# CITY OF ALBUQUERQUE

PLANNING DEPARTMENT – Development Review Services

**RE: Eagle Crest Subdivision (File: C18D064B)  
Drainage Report (stamped 7-3-14) and Supplemental calcs(stamped 8-1-14)  
Grading and Drainage Plan, Engineer's Stamp Date 8-1-14**

DRAWING NO.
DRB 3.0

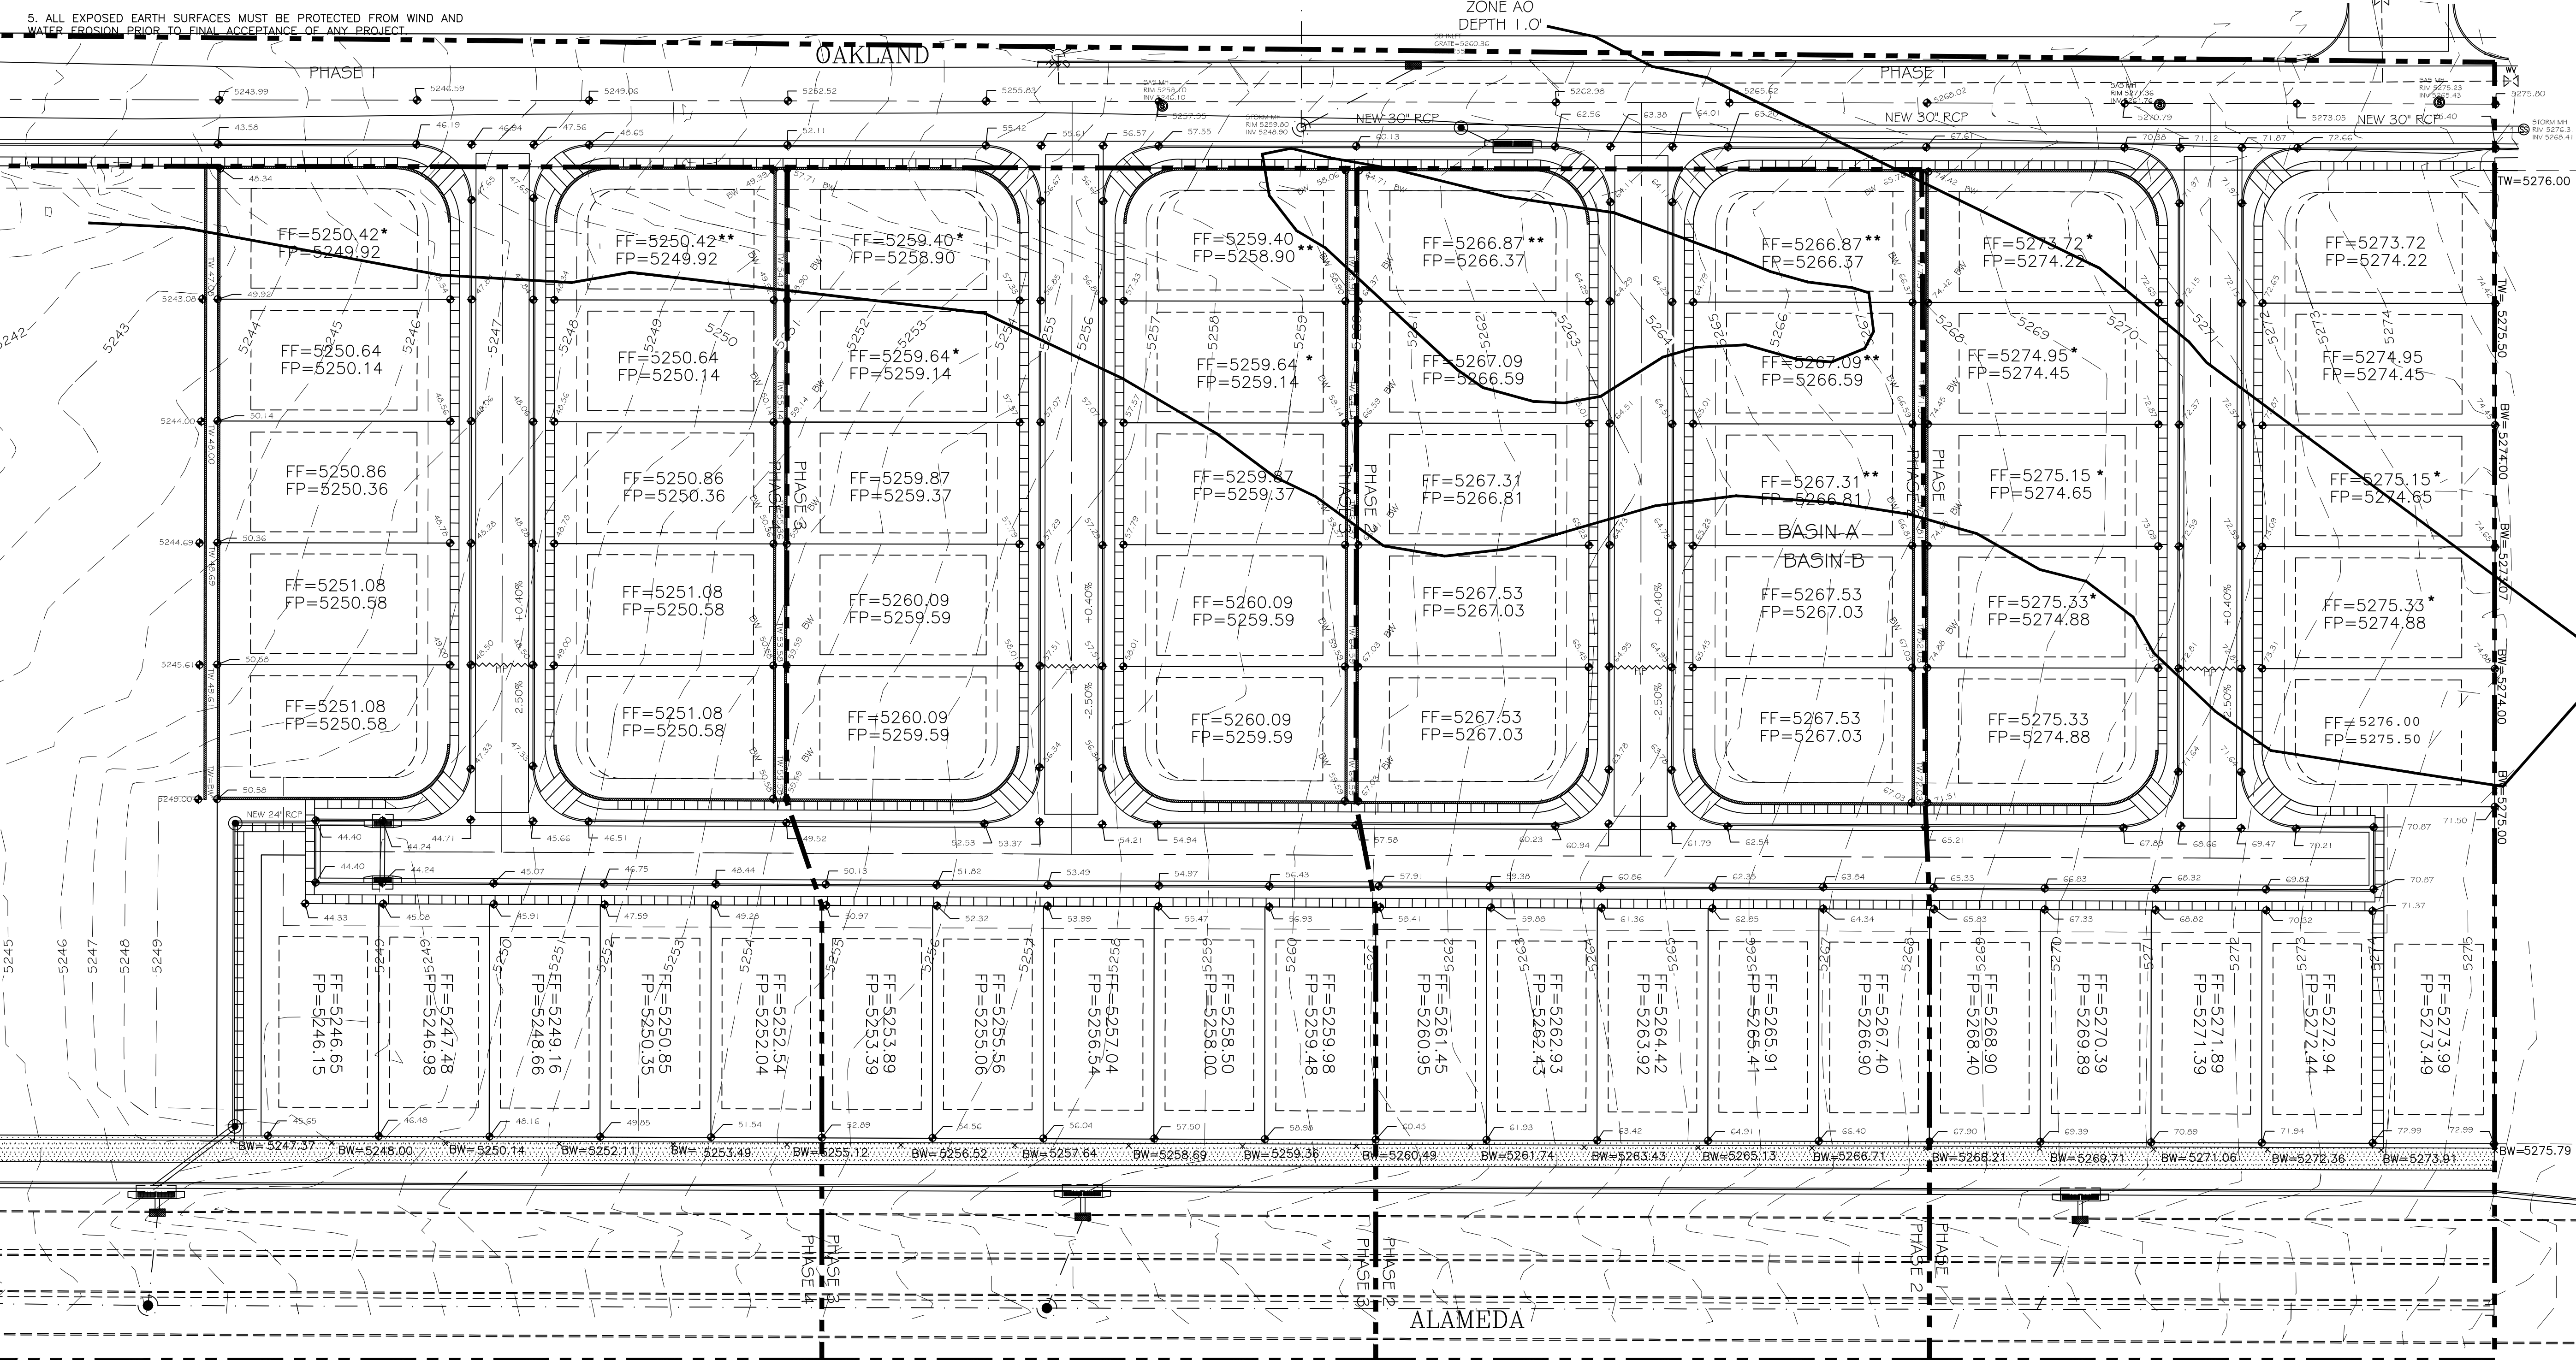
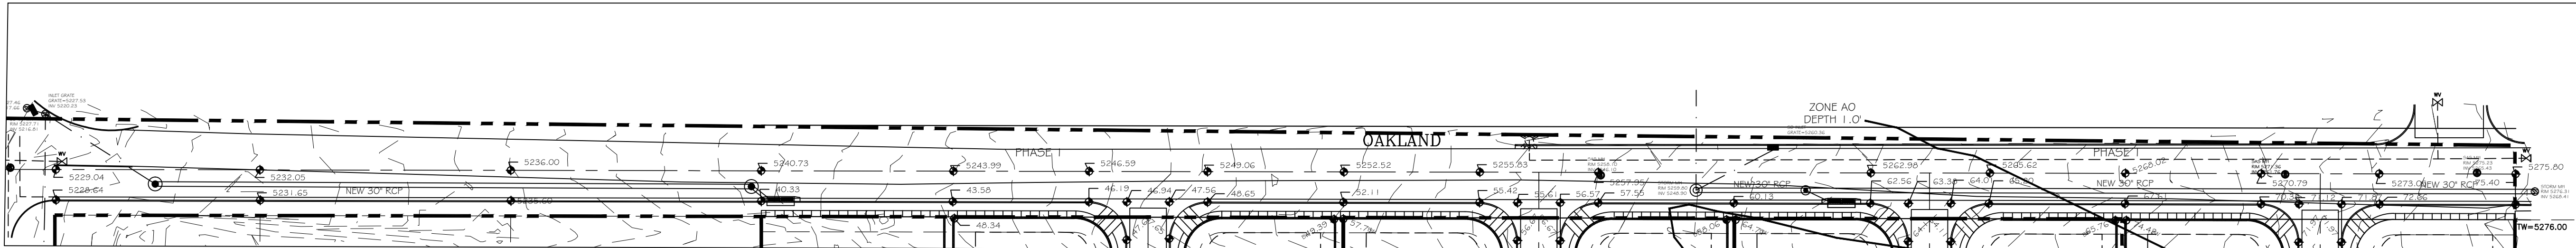
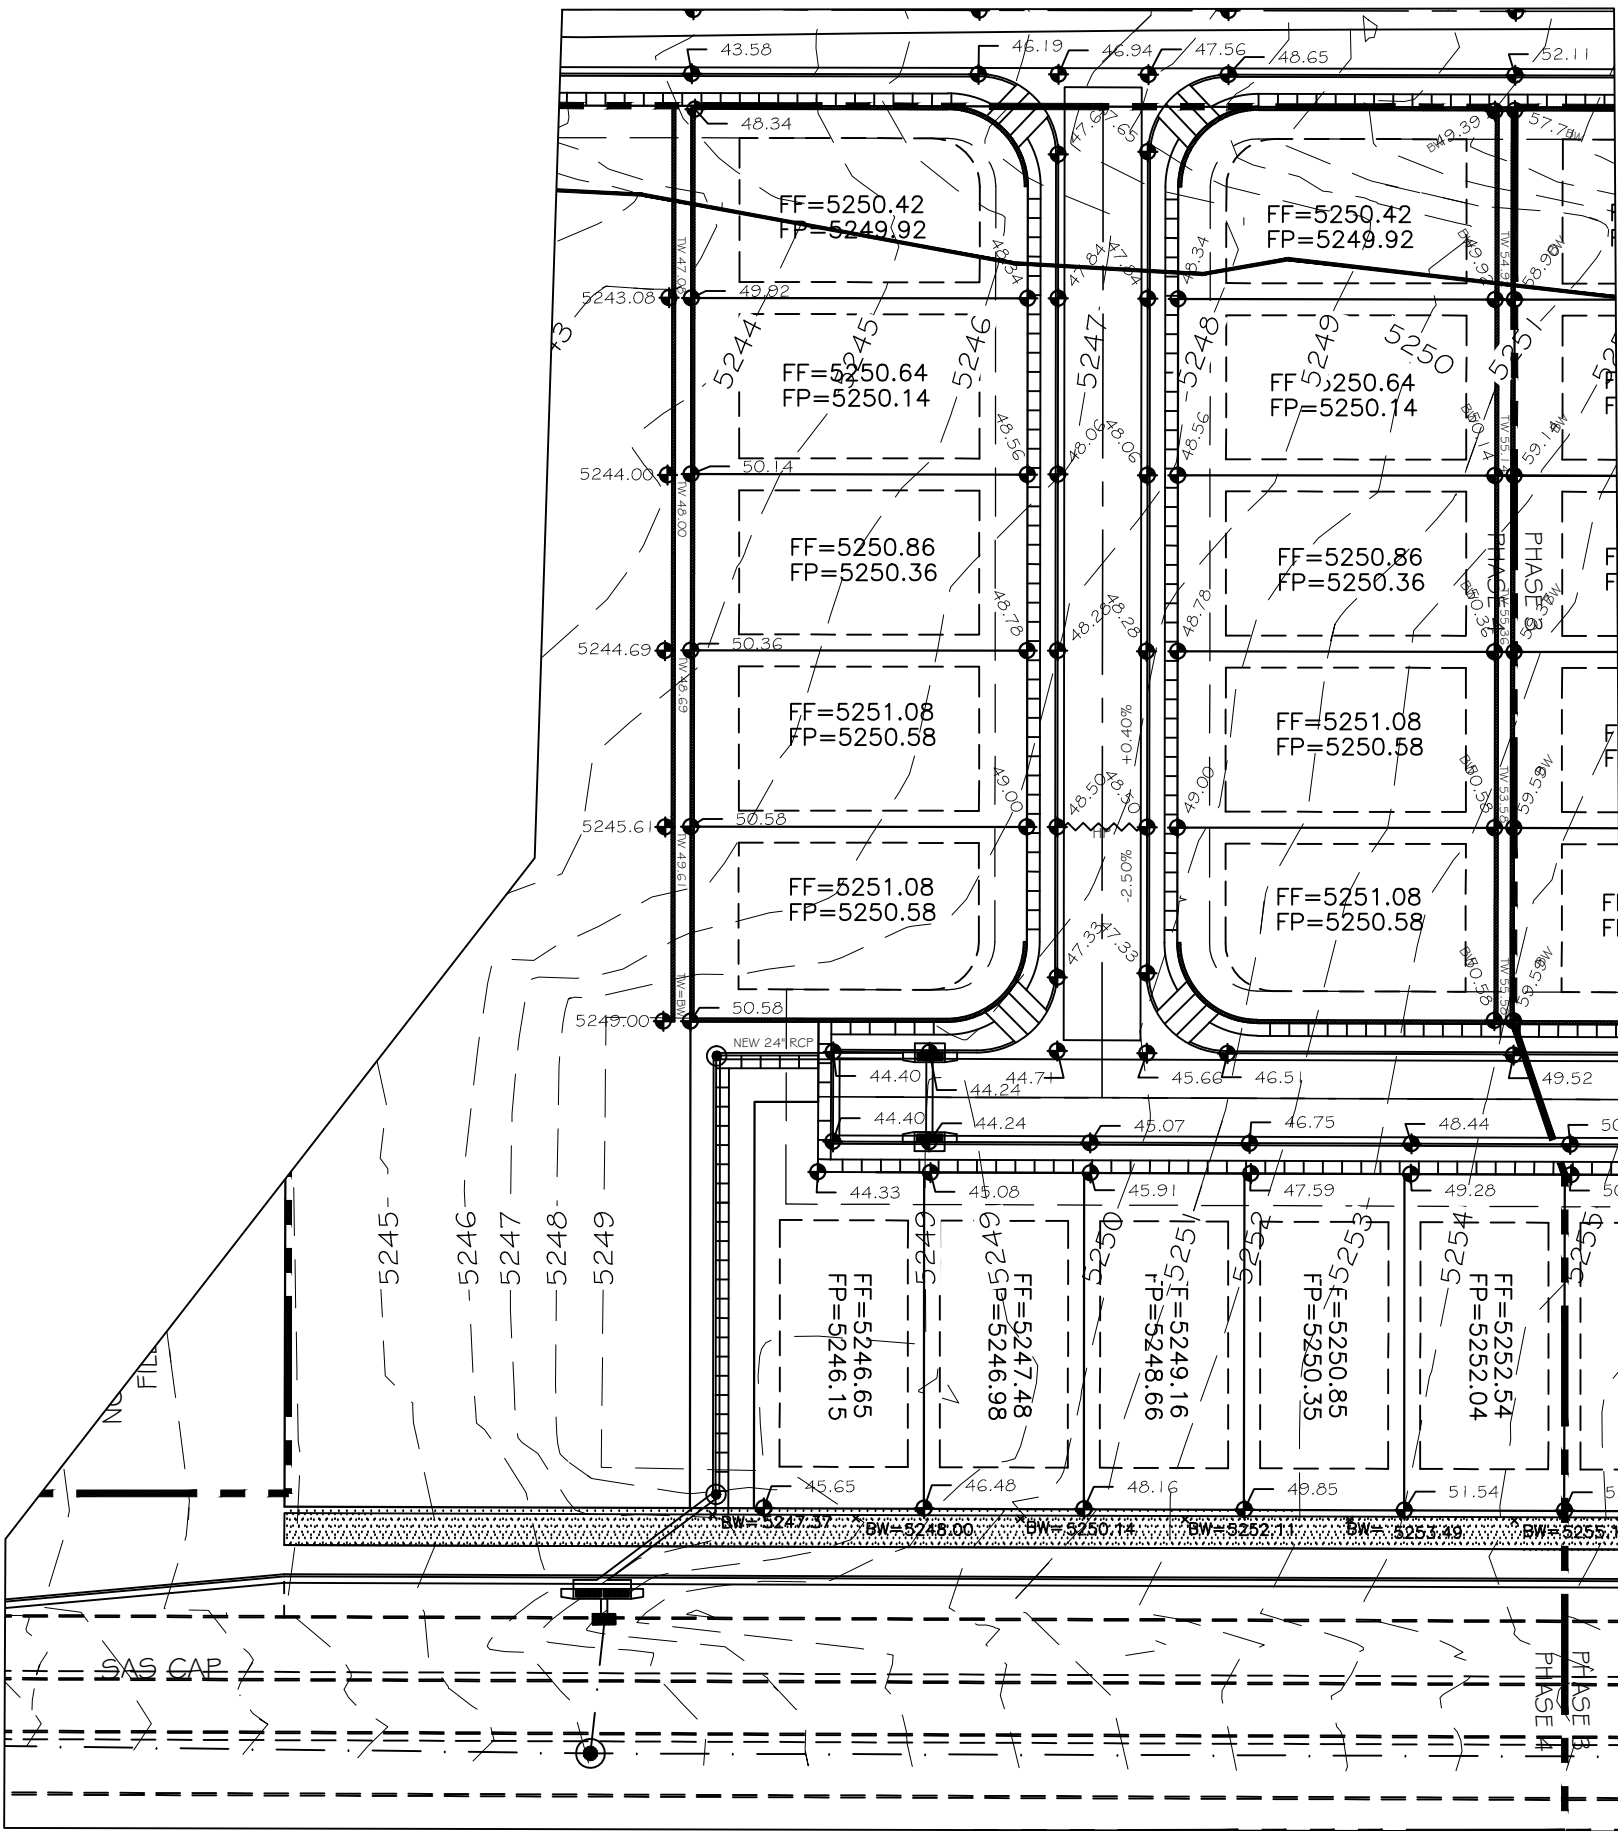
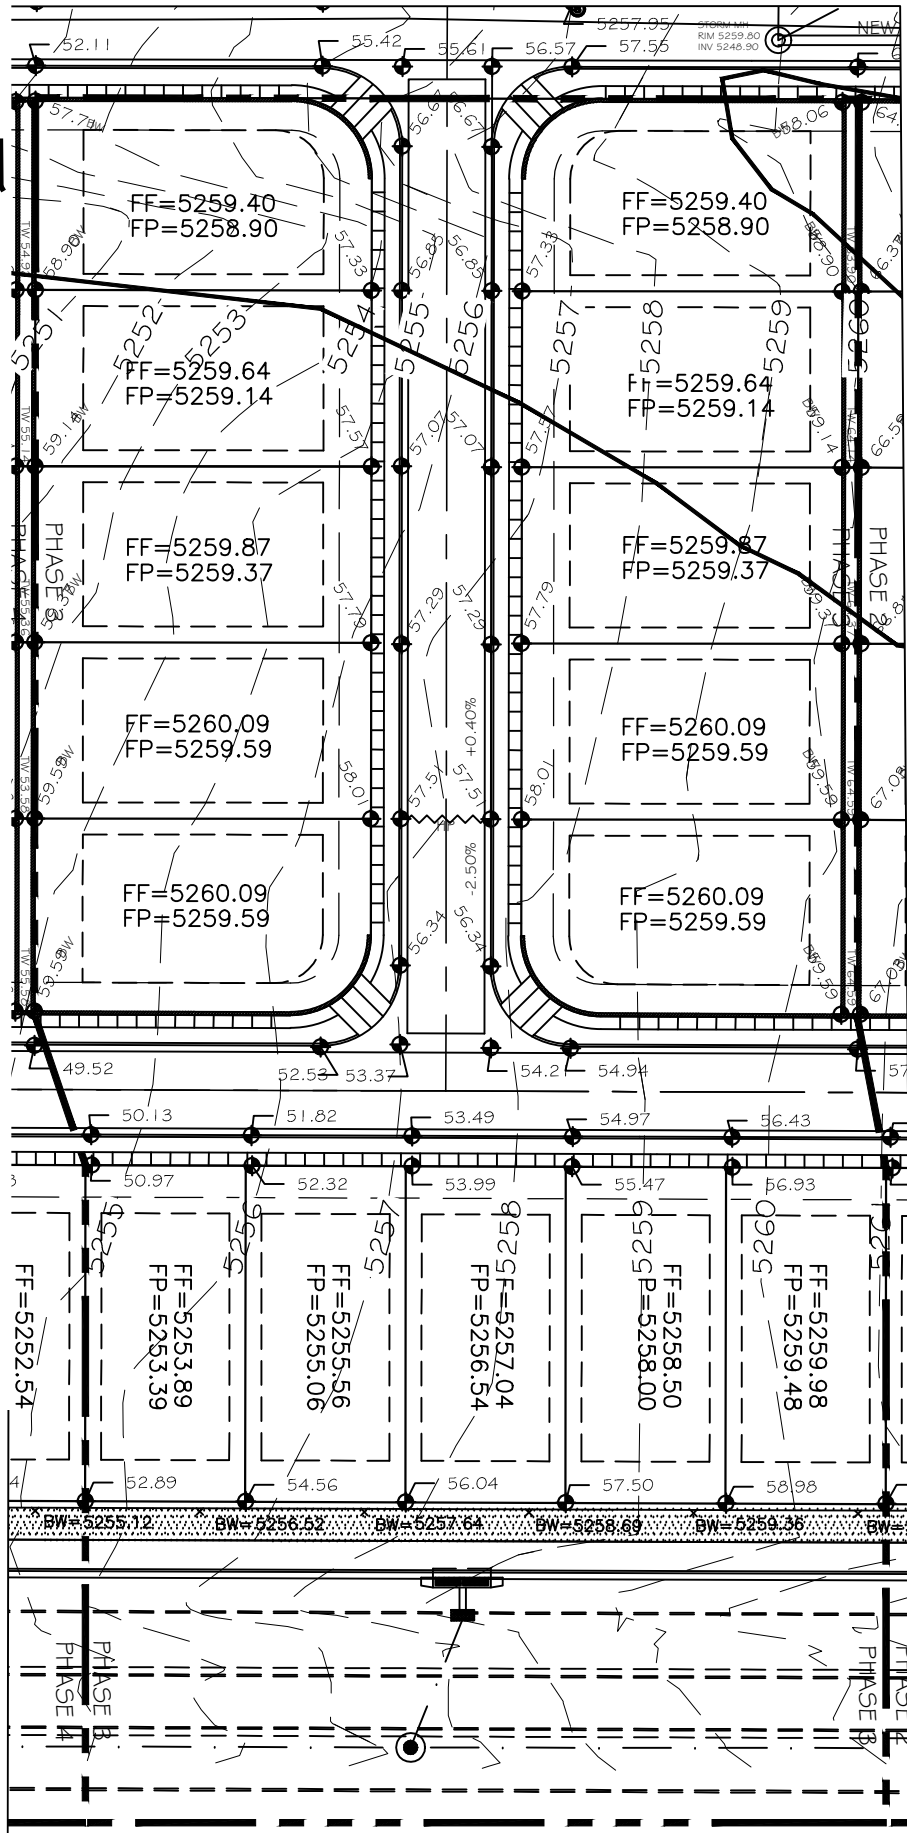
1. Interim Ponds need to be sized and graded on grading plan with WSEL, Vol. and emergency overflow locations. Plats must show a public drainage easement to be maintained by the developer.

5. Define limits of offsite basin "Remainingoak Basin" on a basin boundary map.
6. Use a Match line to continue the Alameda frontage plan.
7. Proposed retaining wall and screen wall are difficult to differentiate. Change the hatch pattern on one or the other.

8. Show spot elevations at retaining walls
9. Update the Unit basin calculation, mainly the narrative and water harvesting in the front yard.
10. Basin map –show limits of basin per phase with different line type or color or both. It looks like B1 and B2 were reduced.

11. Water harvesting ponds – show contour elevations. Appears that another contour is needed.
12. Show flow arrows, proposed contours, street slopes, and street names.
